Dogger Bank South Offshore Wind Farm

Appendix F5 to the Natural England Deadline 5 Submission
Natural England's comments and updated advice on Marine Mammals

Planning Inspectorate Reference EN010125

23rd May 2025

Figure: 4-1		Drawing No: PC2340-RHD-OF-ZZ-DR-Z-1035	
Co-ordinate system: British National Grid		Page Size: A3	Scale: 1:2,200,000
Project: Dogger Bank South Offshore Wind Farms		Report: Marine Mammal Sound Contours

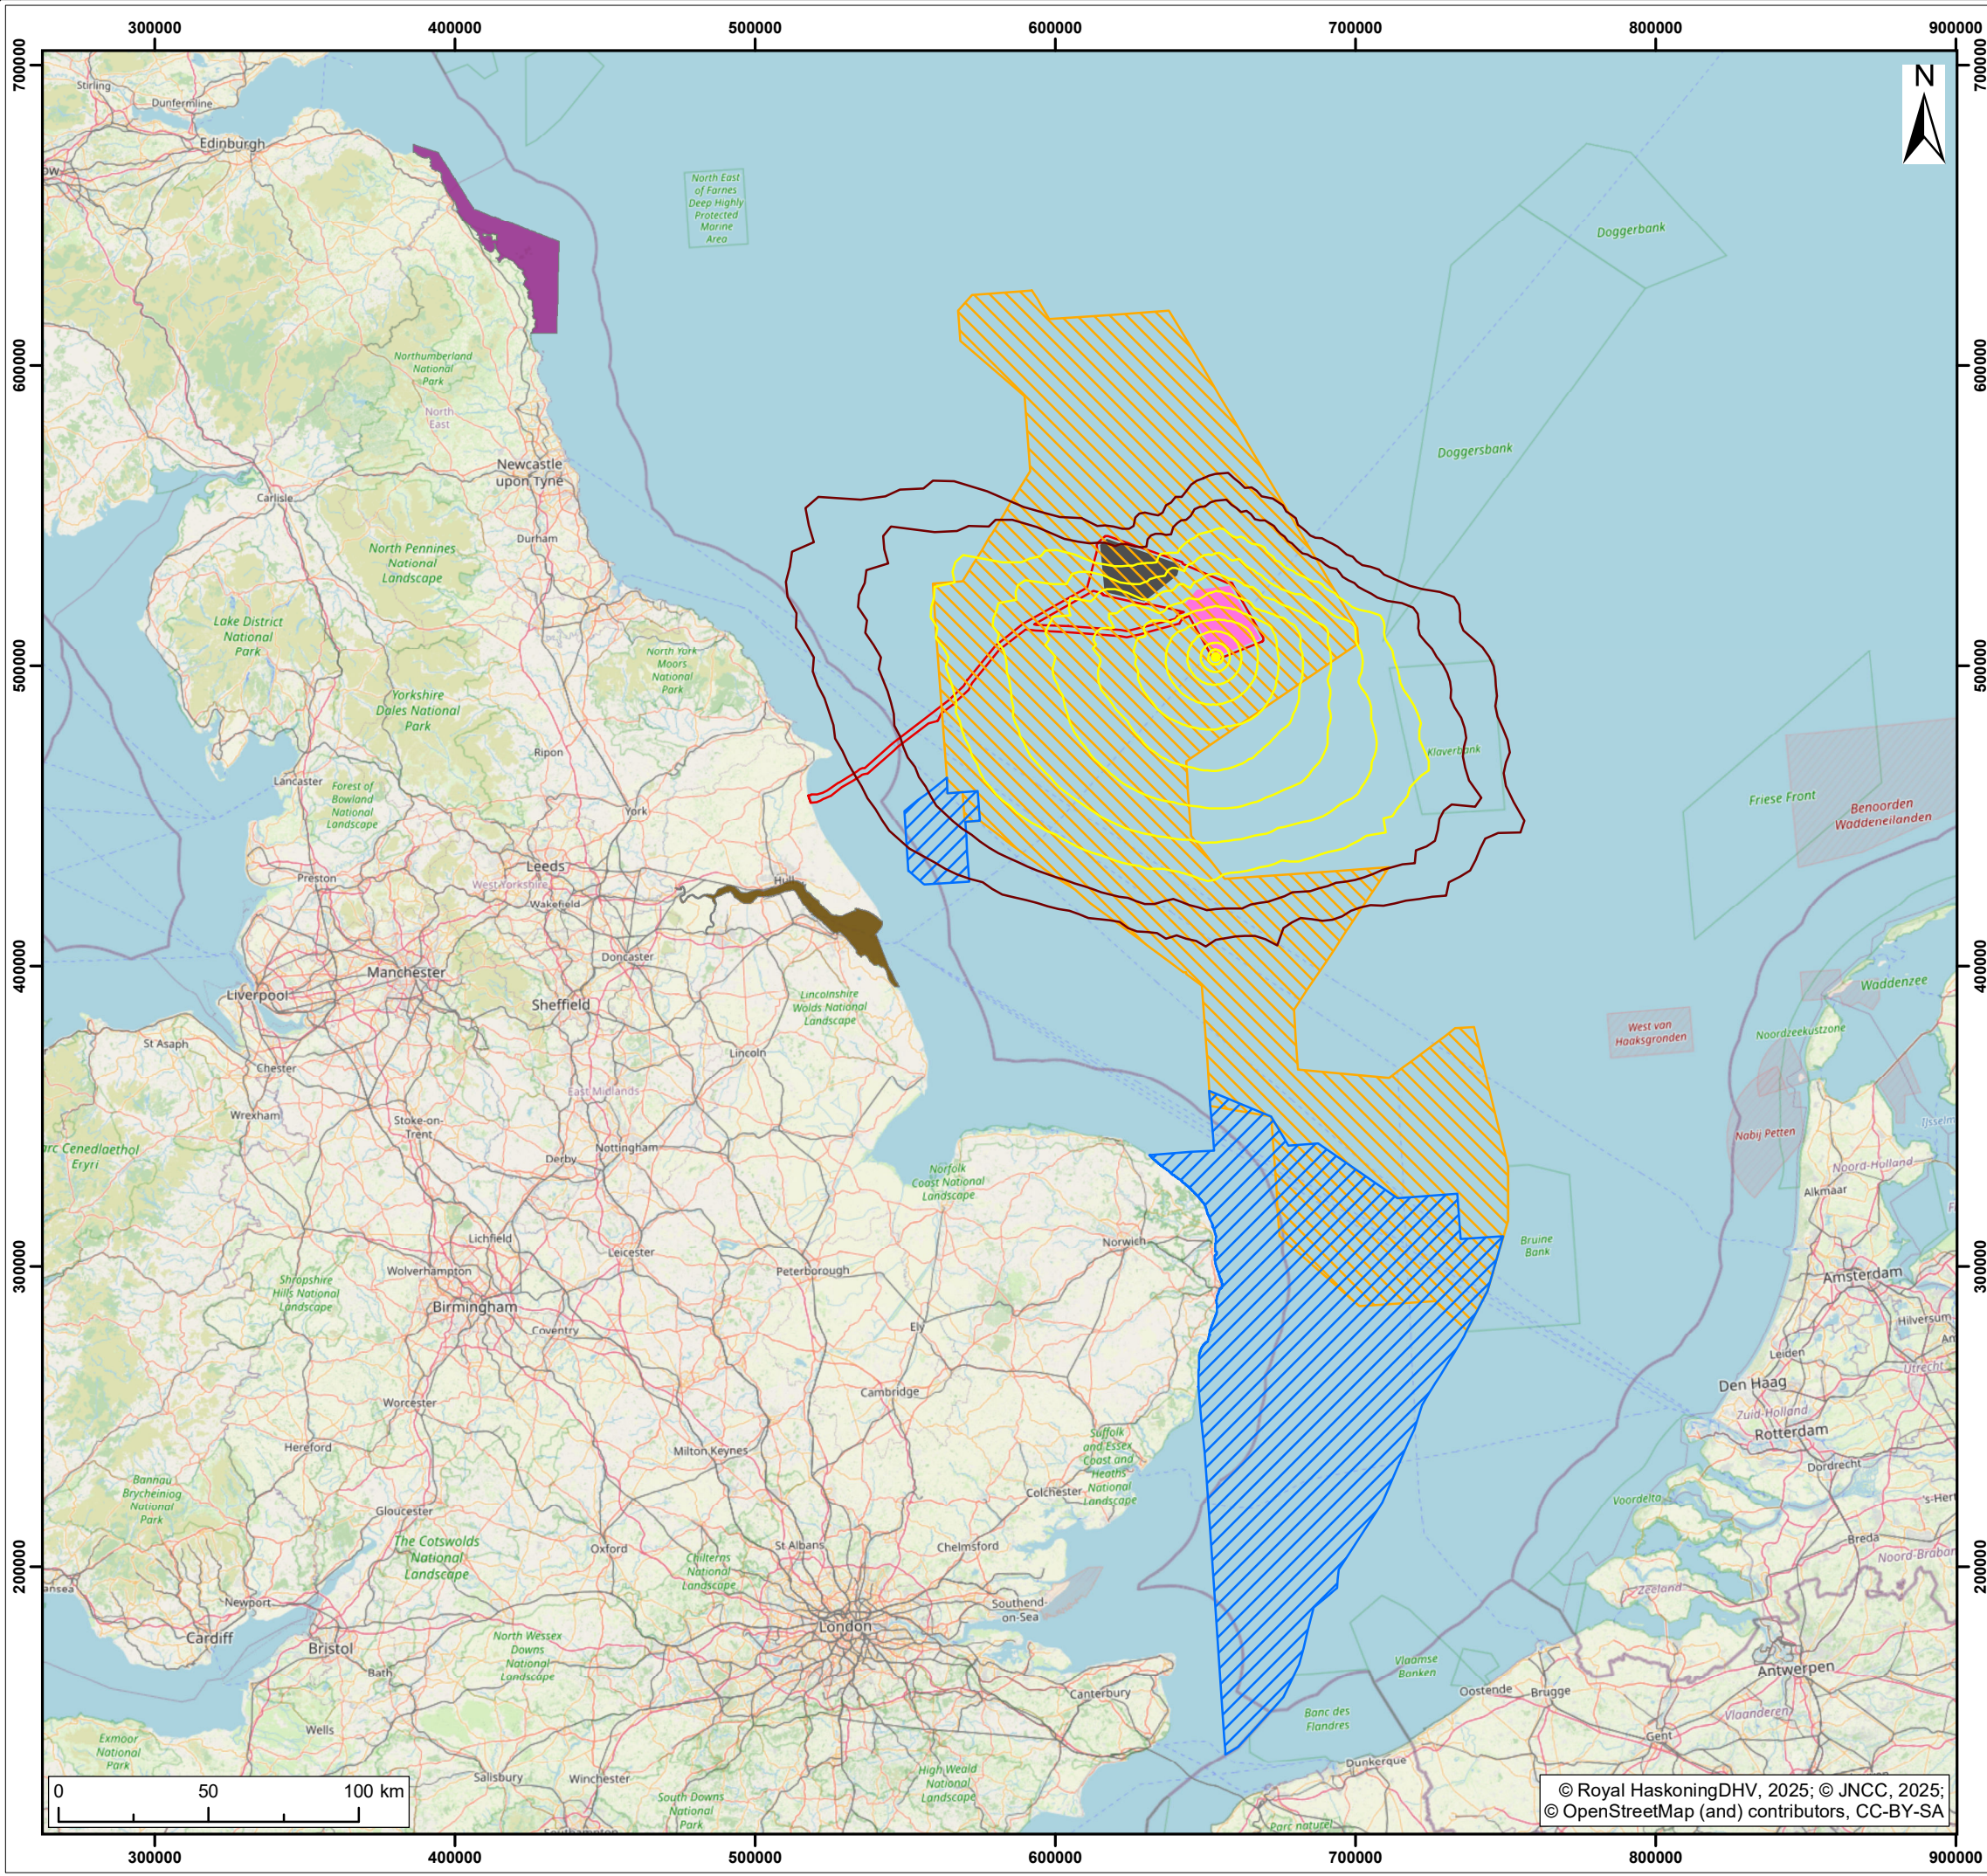
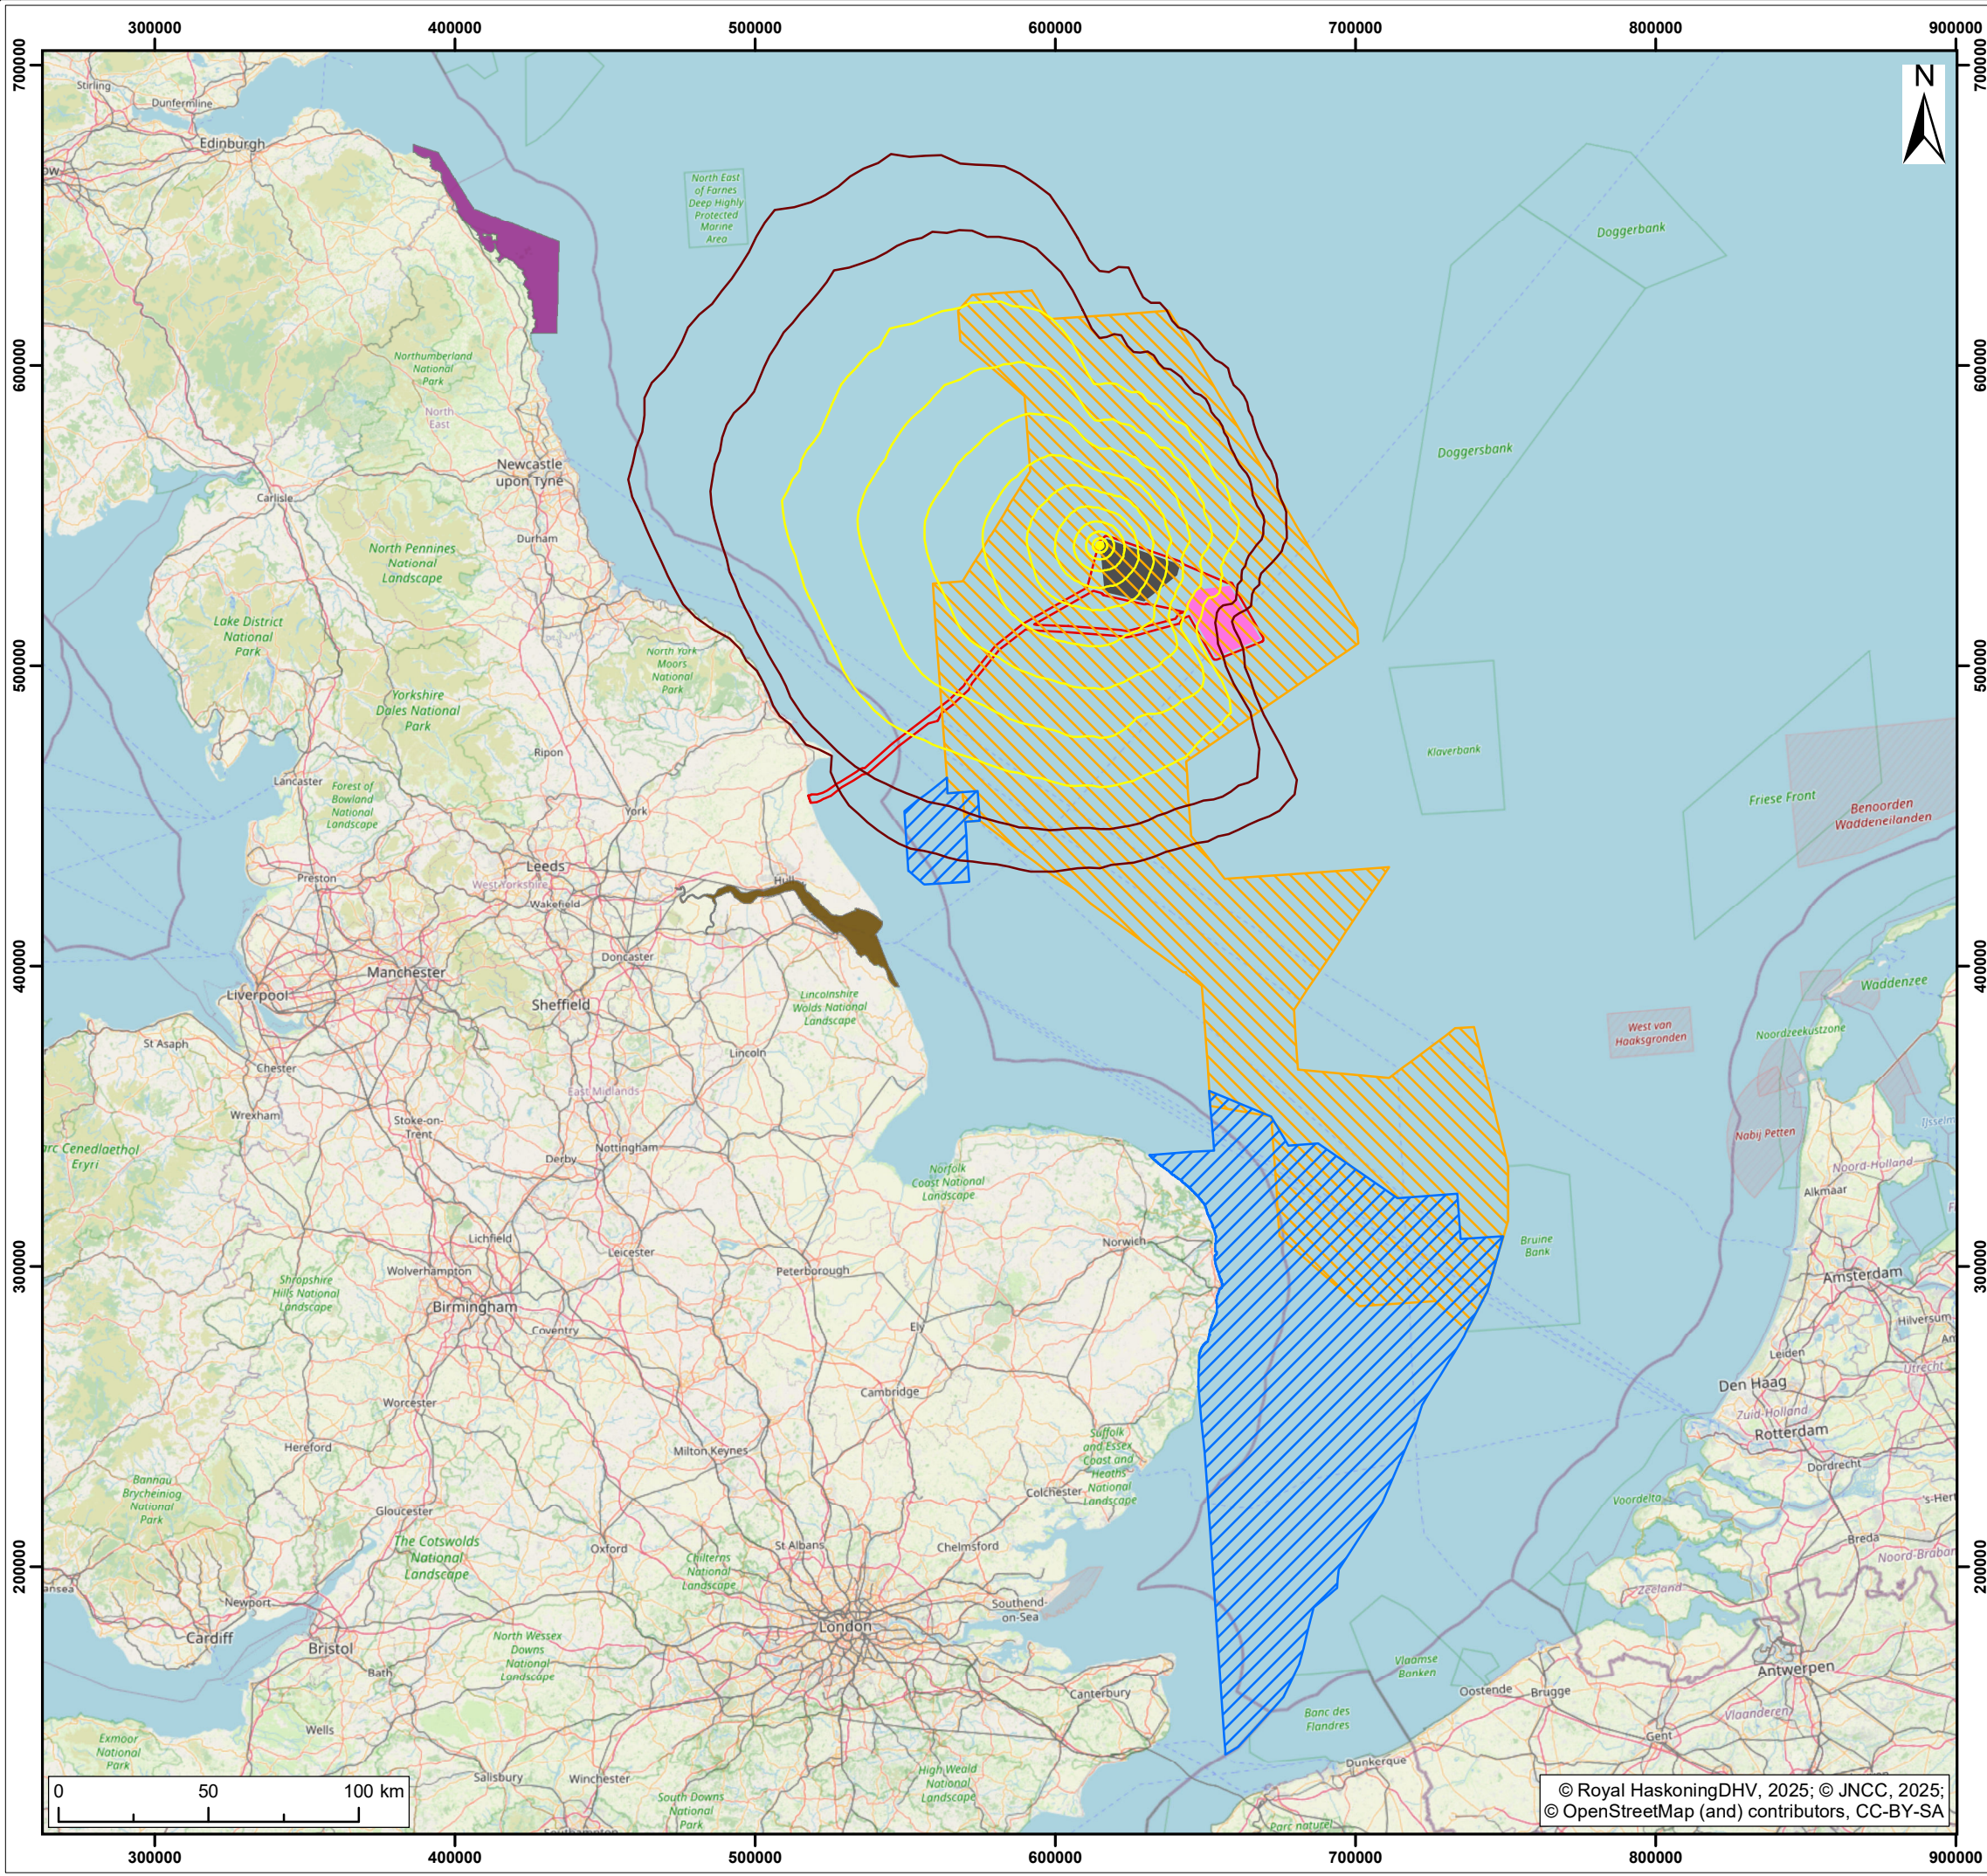
[REP4-094] demonstrates that if a 10 dB reduction in underwater noise (UWN) was achieved through primary or secondary mitigation, impacts to marine mammal species would be significantly reduced. The reductions presented would likely remove the significant impacts on marine mammal populations currently predicted and enable Adverse Effects on Integrity (AEoI) of the Humber Estuary SAC, Berwickshire and North Northumberland SAC and Southern North Sea SAC to be ruled out. They would also reduce the injury zones for minke whale and harbour porpoise to a level that could be fully mitigated with Acoustic Deterrent Devices. This is all welcome, however the Applicant also states that they “*will not be committing to any specific secondary noise reduction methods until the final design parameters, including all relevant primary measures, are finalised post consent*”. Natural England accepts this and does not expect the Applicant to commit to specific secondary noise reduction methods. Instead, we suggest that the Applicant could commit to achieving a 10dB reduction in UWN during construction from levels predicted in the environmental assessment via primary and/or secondary mitigation, with the exact systems and/or technologies to be determined post-consent. **We consider a commitment of this nature to be essential, as unsecured mitigation that may or may not be applied cannot be considered in impact**

assessments. We must therefore base our conclusions on the assessment as it currently stands, whereby our position remains that AEol cannot be ruled out for grey seals in the Humber Estuary SAC for the project in-combination with other plans and projects, for grey seals in Berwickshire and North Northumberland Coast (BNNC) SAC for the project alone, and harbour porpoise in Southern North Sea SAC in-combination with other plans and projects.

As impacts cannot be ruled out at this time, particularly for the Project alone and injury zones, it is not in doubt that additional mitigation will be needed post-consent. Further, as the Applicant considers that a (minimum) 10dB reduction is both achievable and necessary to reduce impacts, we do not consider that it is unreasonable to expect the Applicant to commit to additional mitigation at this stage. We also highlight that commitments of this nature are not without precedent. During the Rampion 2 OWF Examination, the Applicant committed to a 15dB reduction through the use of NAS to reduce UWN impacts on black seabream in the Kingmere MCZ.
